Please upload onto Ocella the email below which is the revised consultation response from **ADC Drainage Engineers** to discharge of condition application **BE/21/20/DOC** – Salt Box.

Engineers comments in respect to surface water drainage;

APPLICATION NO: BE/21/20/DOC

Site Address: Land At Salt Box West Of Shripney Road Bognor Regis PO22 9NW

HYDROCK PROJECT NO. C-13319-C		SCALE @ A1 1:250	
STATUS DESCRIPTION TENDER			STATUS D2
DRAWING NO. (PROJECT CODE-ORIGINATOR-ZONE-LEVEL-TYPE-ROLE-NUMBER) SAL-HYD-PH2-ZZ-DR-C-7011			REVISION P03

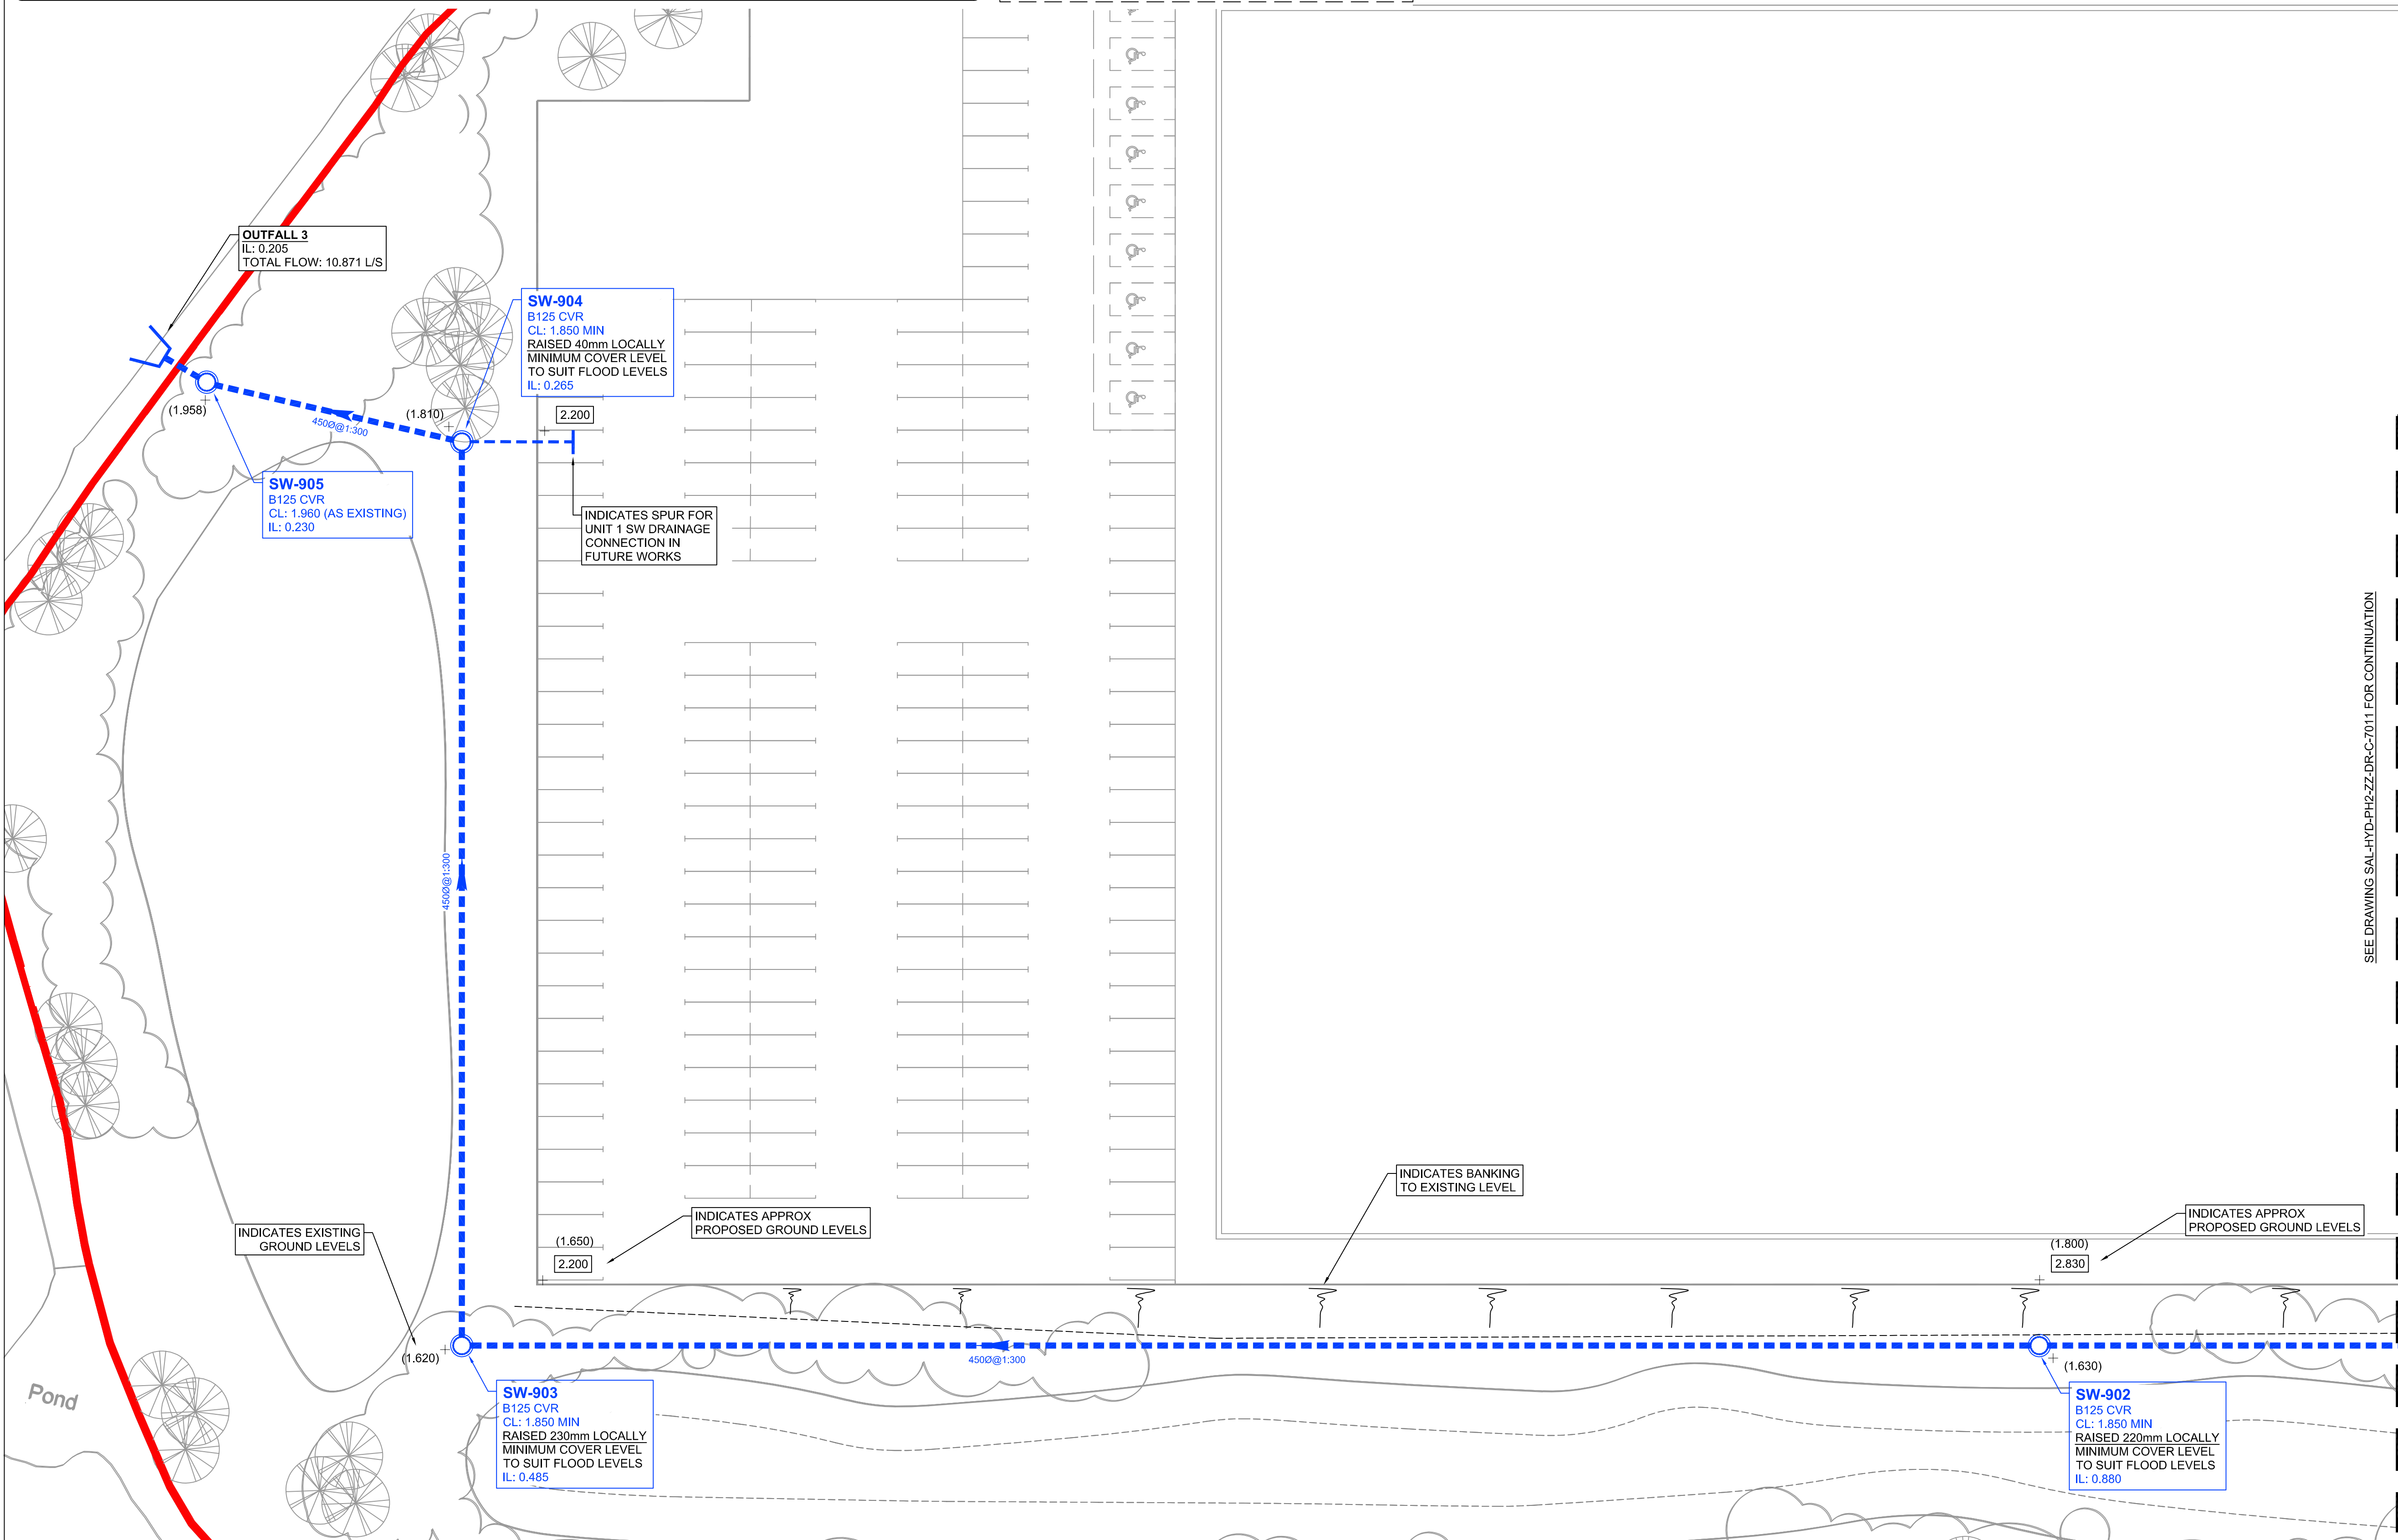
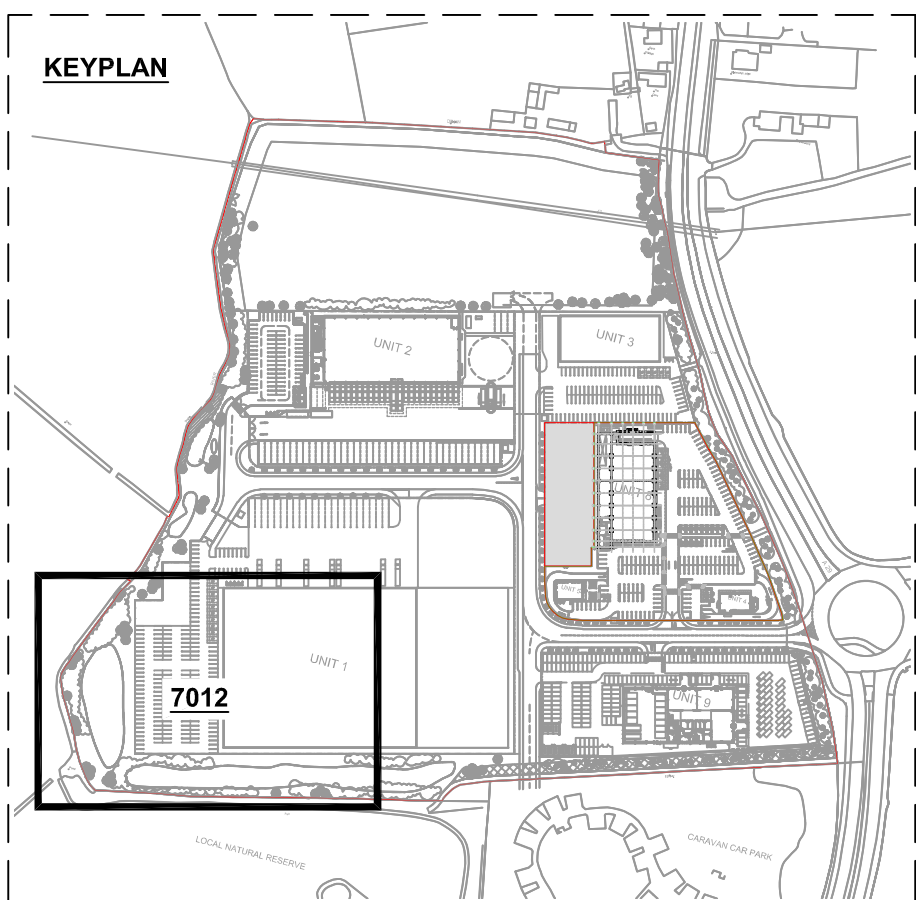
7. Manhole SW-900 invert level is different on plans 7011 and 7022. Noted.

9. Drawings 7011 and 7012 – Remove any trees etc being shown within proximity of the proposed pipeline.
Noted. Trees removed. ok
10. Improve gradient FC-401 to 01-401 to min 1 in 400.
Pipe gradient updated. ok

PH1-7022 IL revised to suit PH2-7011. ok

DETAIL PG: PAVED GULLY
SCALE 1:10

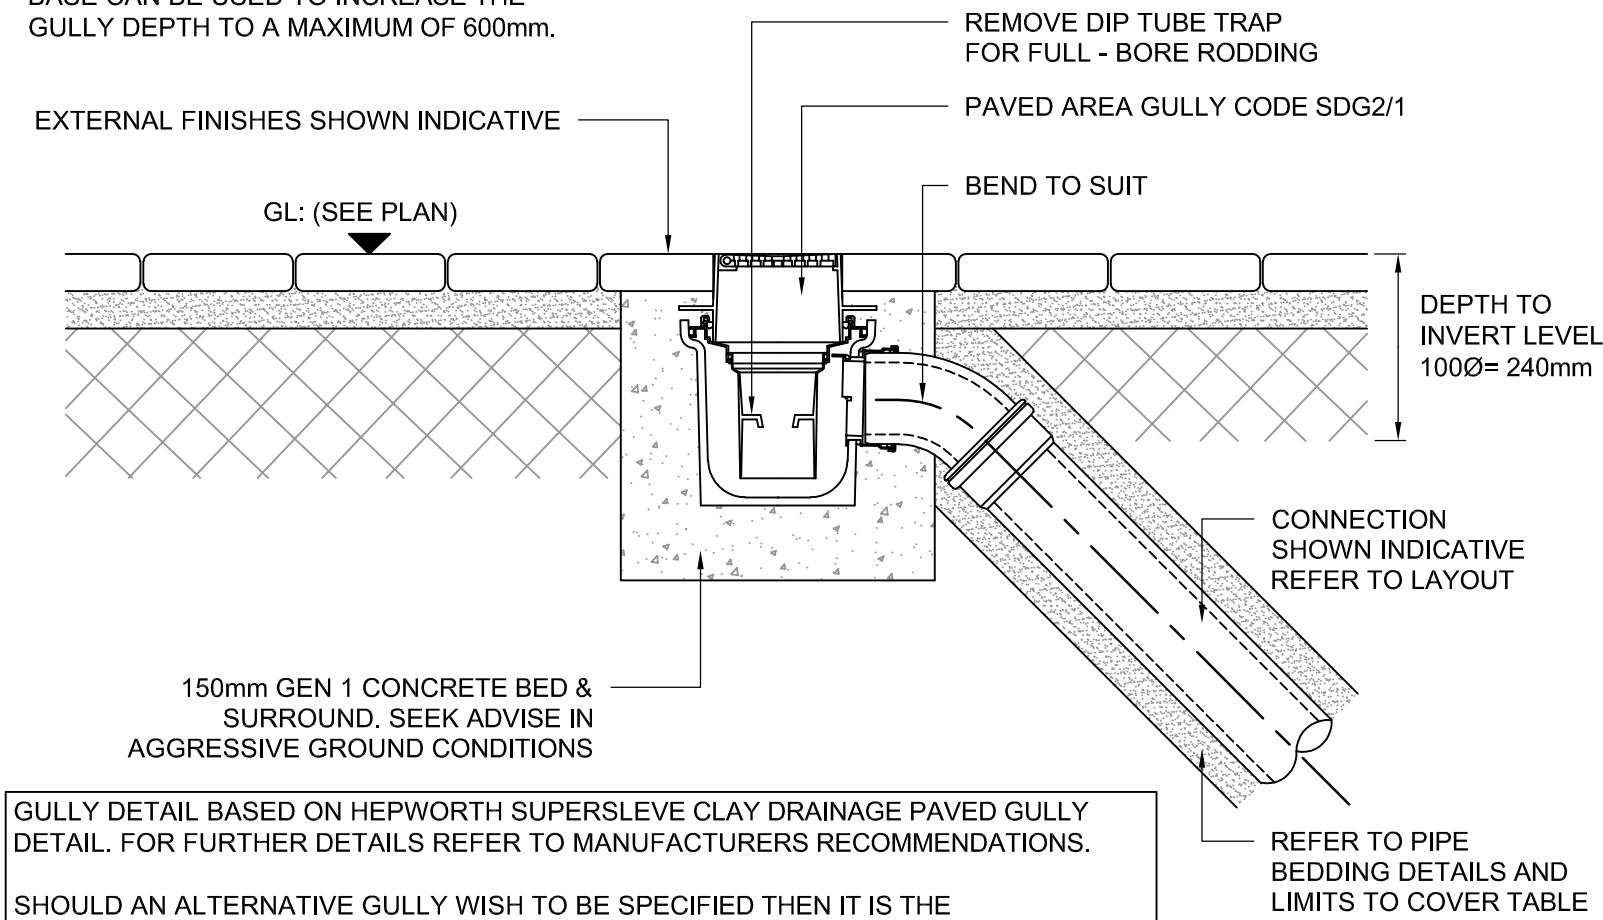
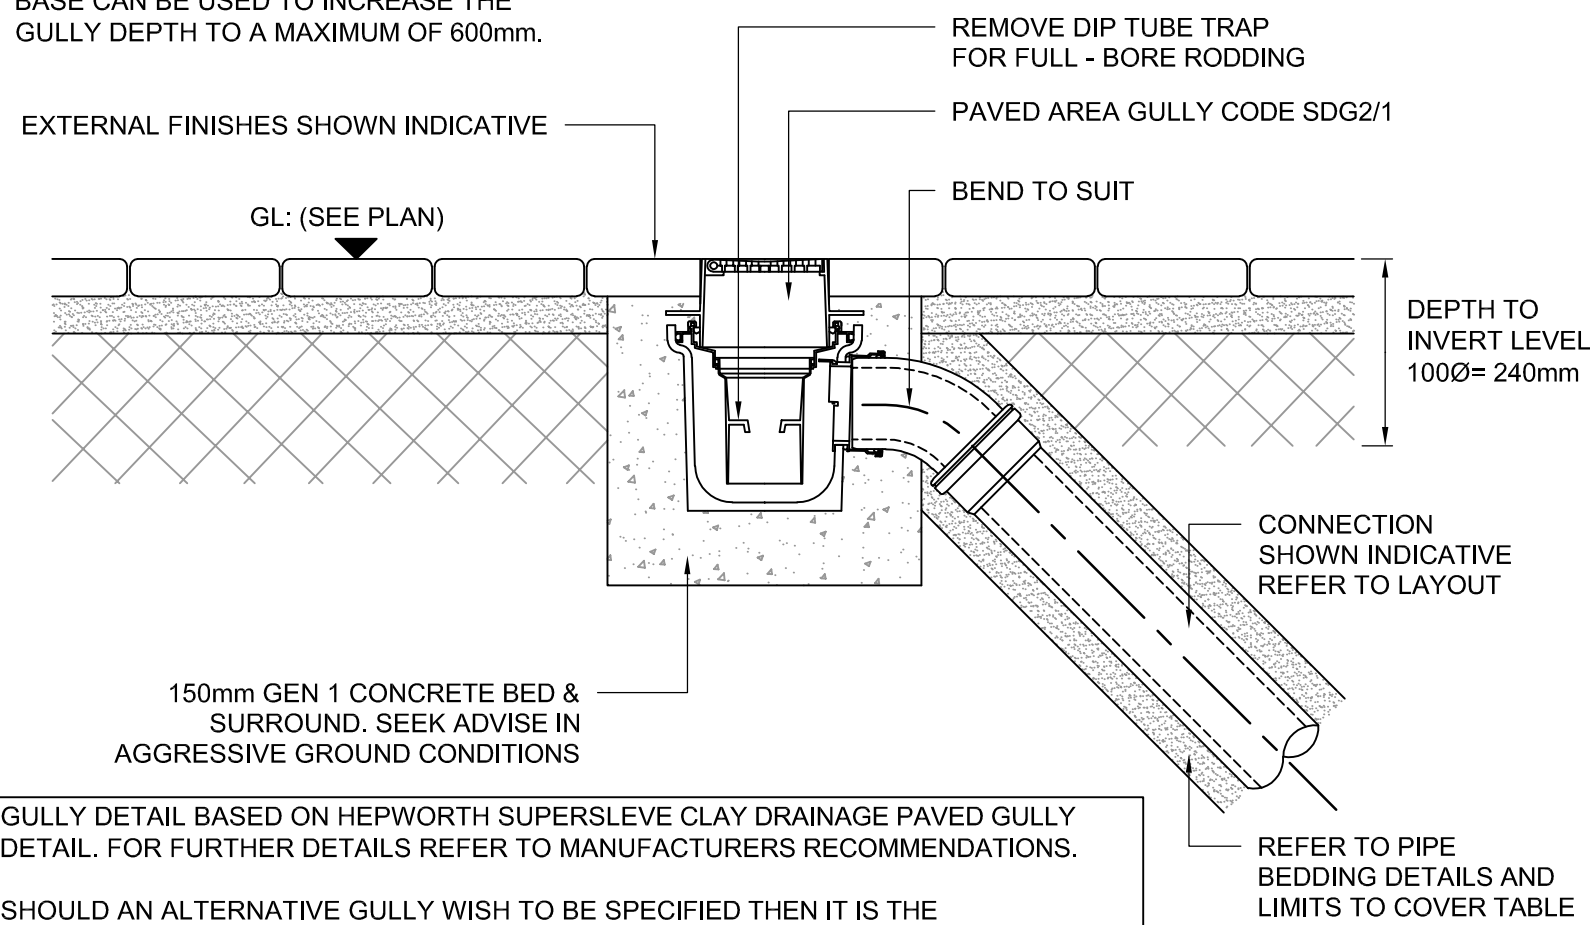
11. Specify gradient and pipe diameter (FC-401 to SW-1000) on drawings 7010 and 7021.
Pipe gradient added ok
12. Provide PG paved area gully construction detail (to incorporate silt trap).
PG detail added ok

UNIT 4, 5 AND 8 FC-401
DETAIL FROM HYDRO INTERNATIONAL
SCALE 1:20
(REFER TO C-7020 FOR LOCATION)

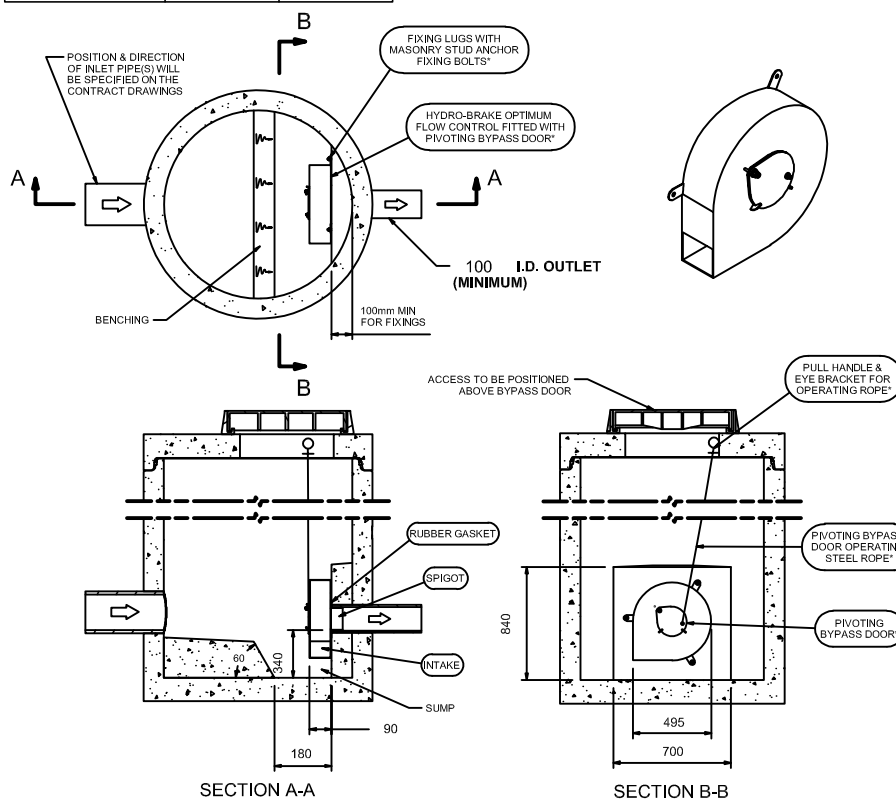
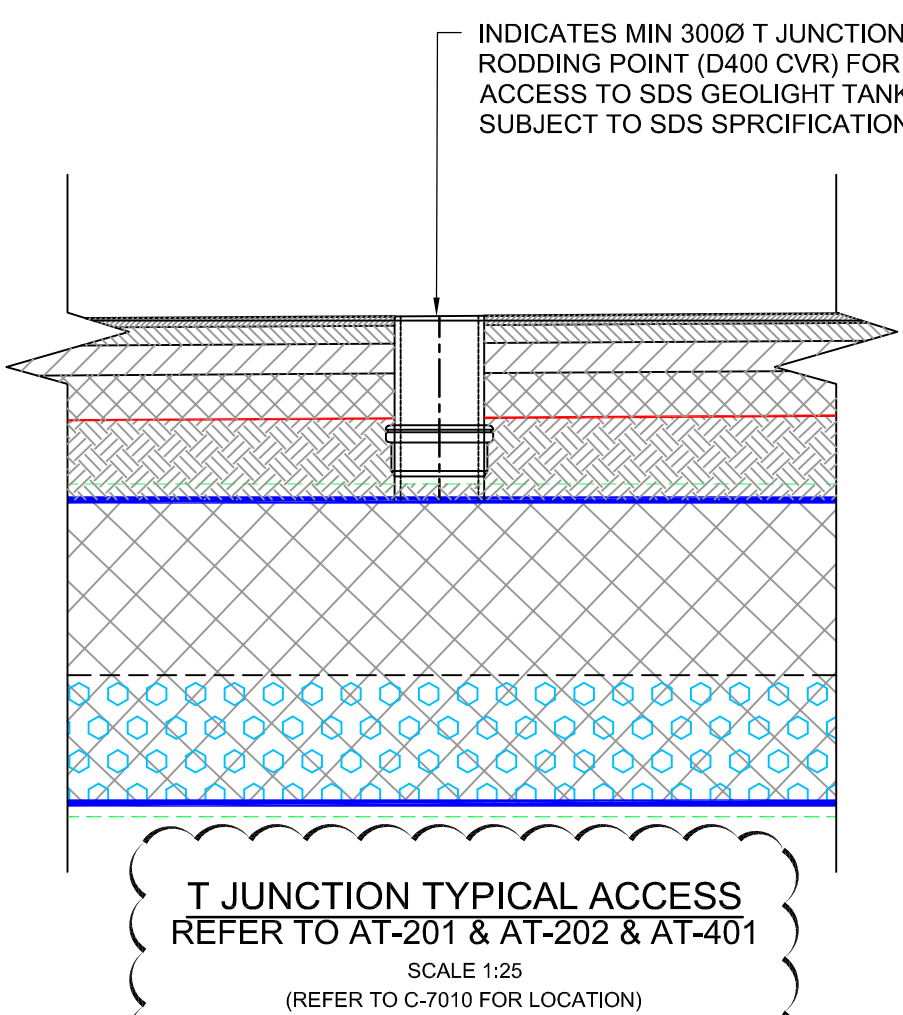
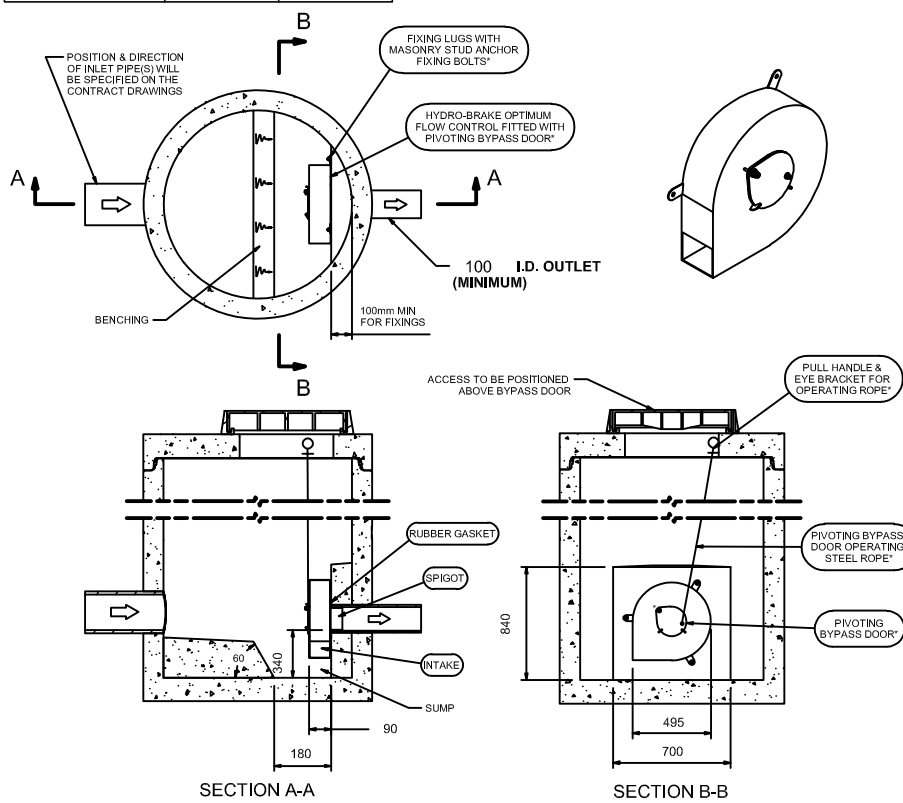
22. FC-401 – specify hydrobrake model and discharge on drawing 7103 (Phase 2)
Full detail can be found on drawing 7103. Flow note added. Now shown on 7101 but hydrobrake model not indicated? Model added. ok
